## WEST SUSSEX COUNTY COUNCIL CONSULTATION

| <b>LOCATION:</b>                | Land to the Rear of 1 The Heathers<br>Arundel Road<br>Angmering<br>BN16 4LE                                                                                                                                        |
| <b>SUBJECT:</b>                 | A/30/20/PL<br><br>Demolition of existing building & construction of 2-bedroom bungalow with associated parking & landscaping (resubmission following A/146/19/PL). This application affects a Public Right of Way. |

Proposed Bungalow Plans and Elevations

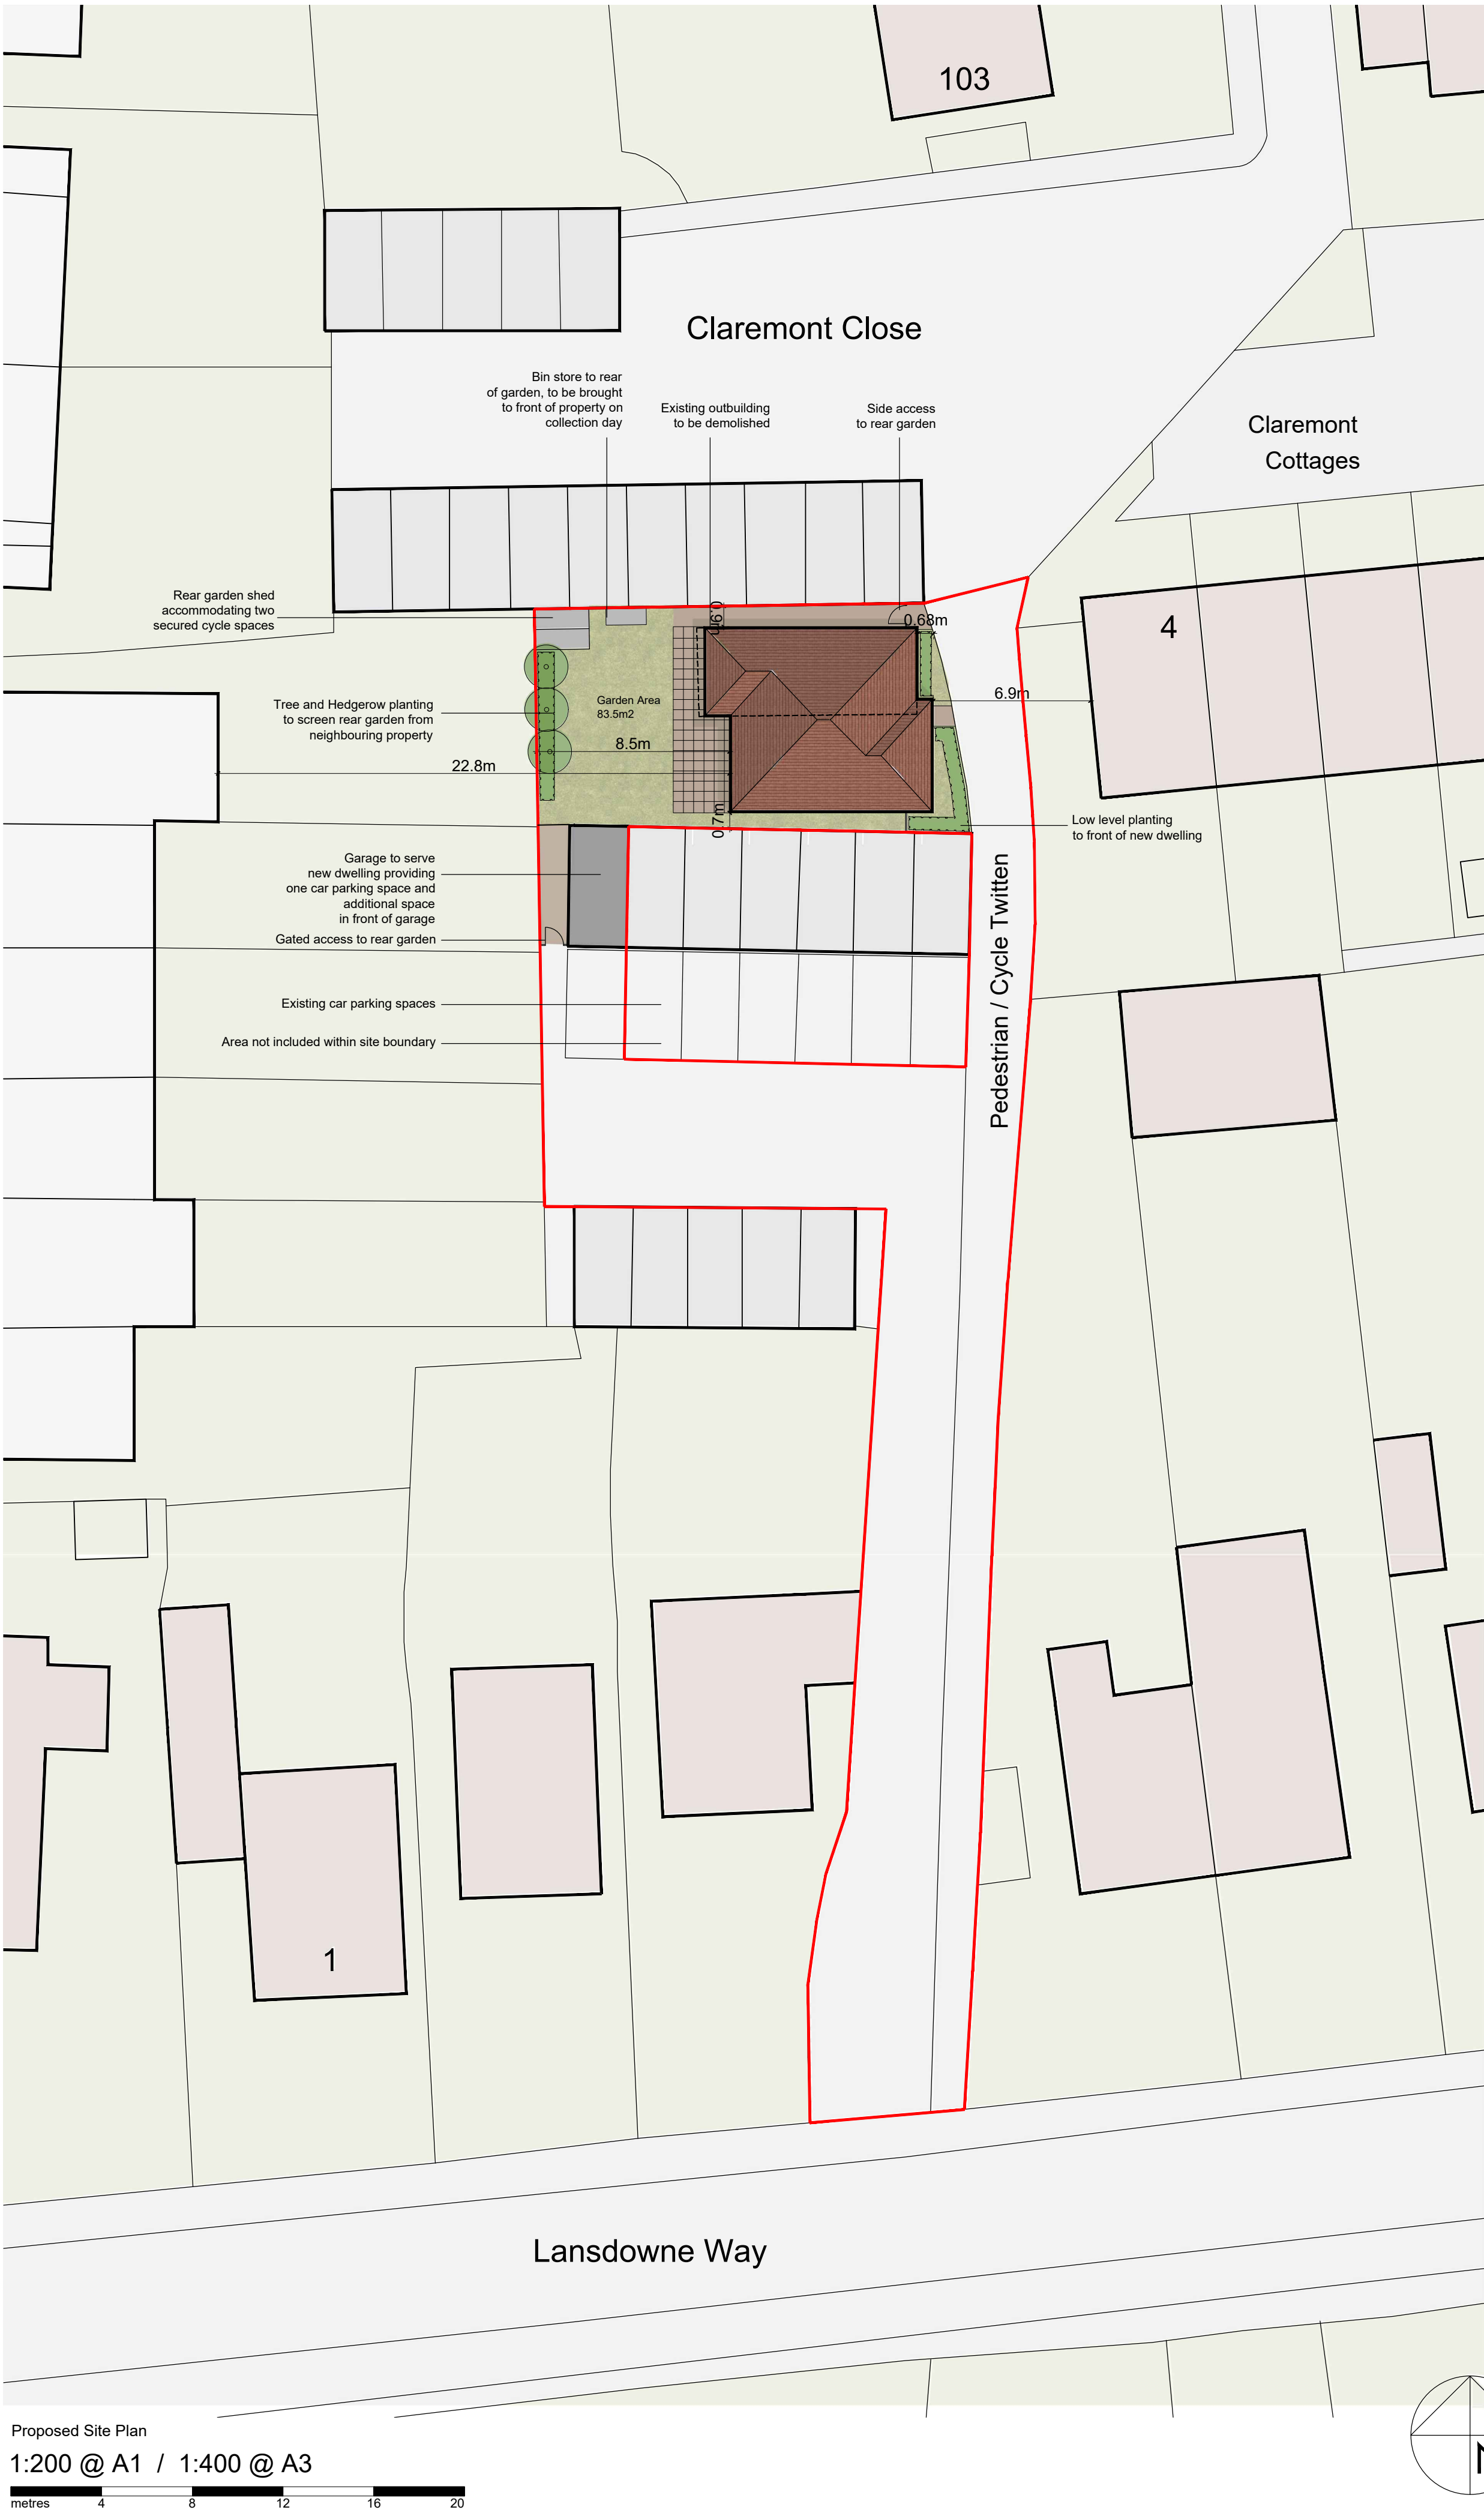
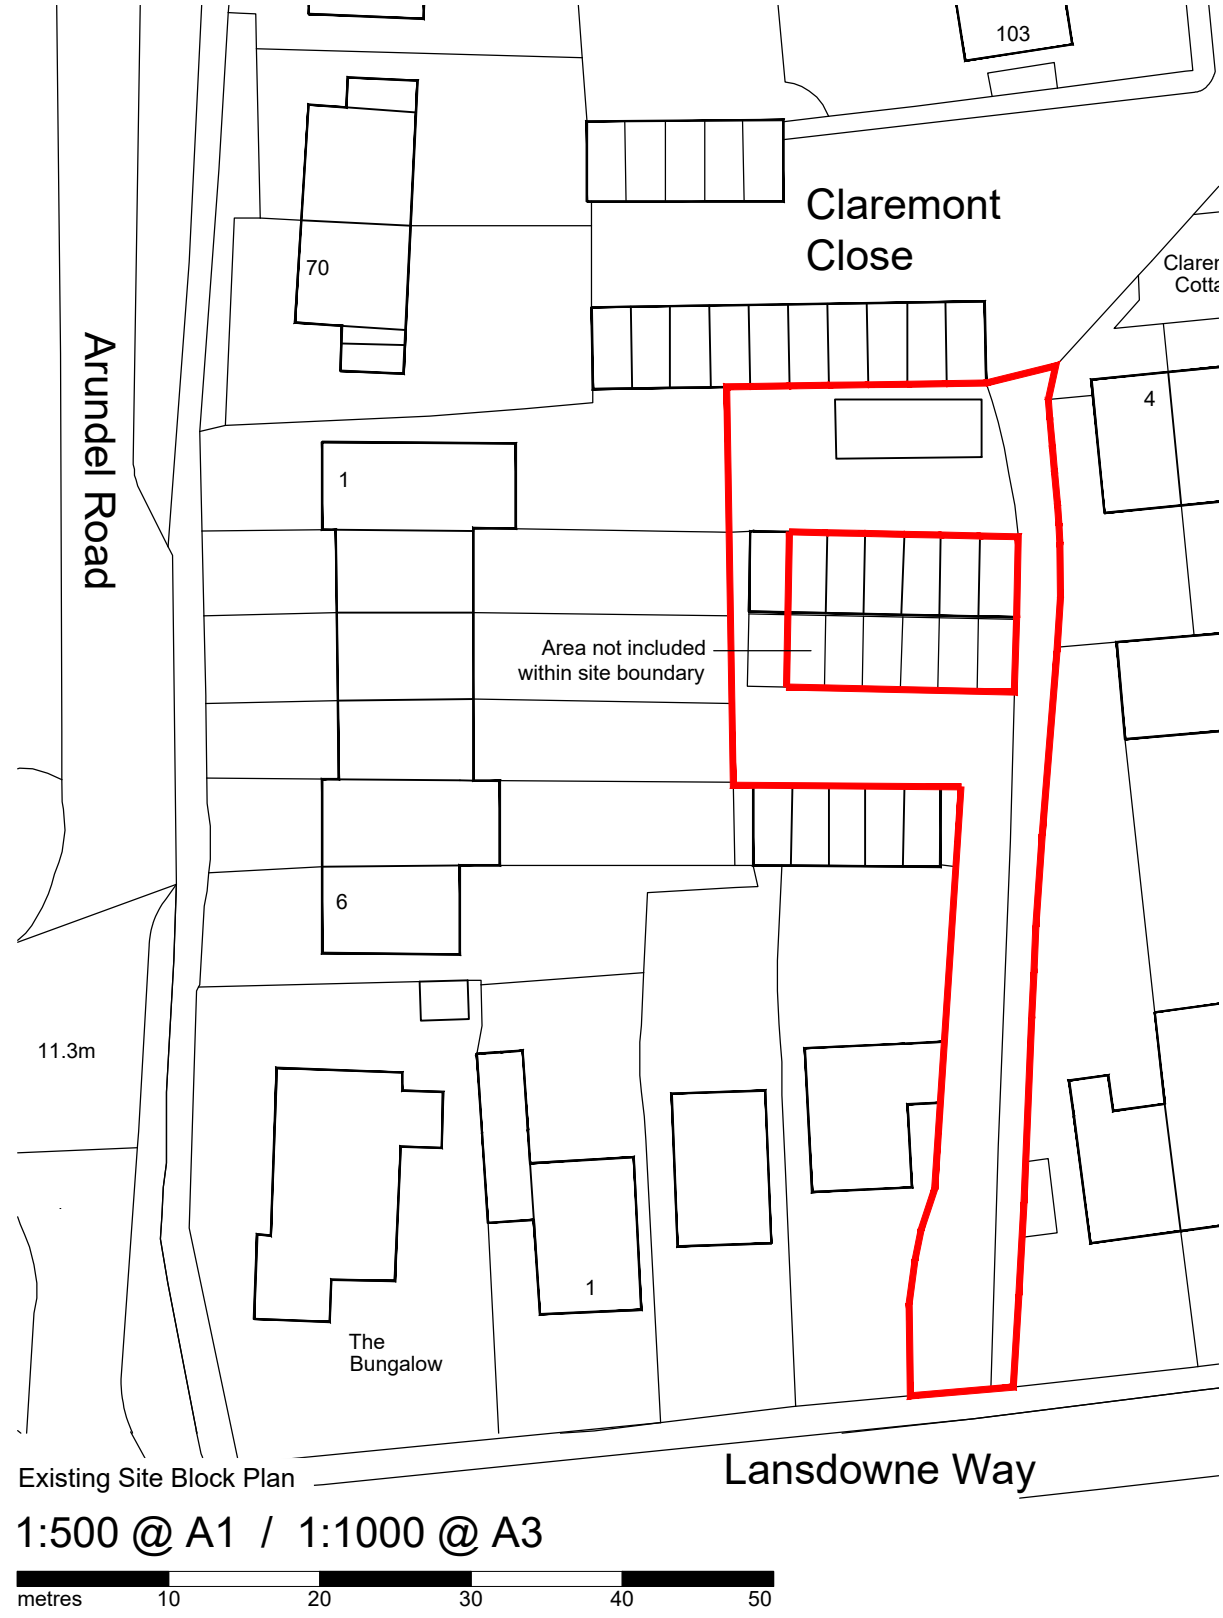
A second access is located on foot via Lansdowne Way to Goring Close a publicly maintained footway. It appears that the gate/access path from the footway to the

dwelling may result in a conflict with a street lighting pole. The applicant is advised to contact the operator in regards to the possible relocation works associated.

The applicant has provided plans demonstrating the use of a garage and a single parking space located to the south of the proposal in a communal parking area.

After inspection of these plans, the LHA advise that the garage (2.6 x 5.3 metres) does not conform to Arun Parking Standards for garage dimensions (3 x 6 metres). On this basis, the LHA will not consider the garage towards the parking provision of the site.

Therefore, a one allocated car parking provision is proposed for the new two-bedroom dwelling. Under the Arun Parking Standards (adopted January 2020), two car parking spaces plus one visitor space should be provided for the proposal.

Though the garage does not meet standards to be considered towards the parking provision of the site, the LHA takes the view on garages giving the opportunity to provide covered, lockable cycle storage.

The site is located in a sustainable location within walking and cycling distance to a range of public services, amenities and employment options. Bus (150 metres) and rail station (2 km) provide a realistic travel opportunity for longer trips. It would not be anticipated that future occupiers of the dwelling would be reliant on the use of a private motor vehicle. As a result, the applicant has provided cycle storage in the form of a garden shed.
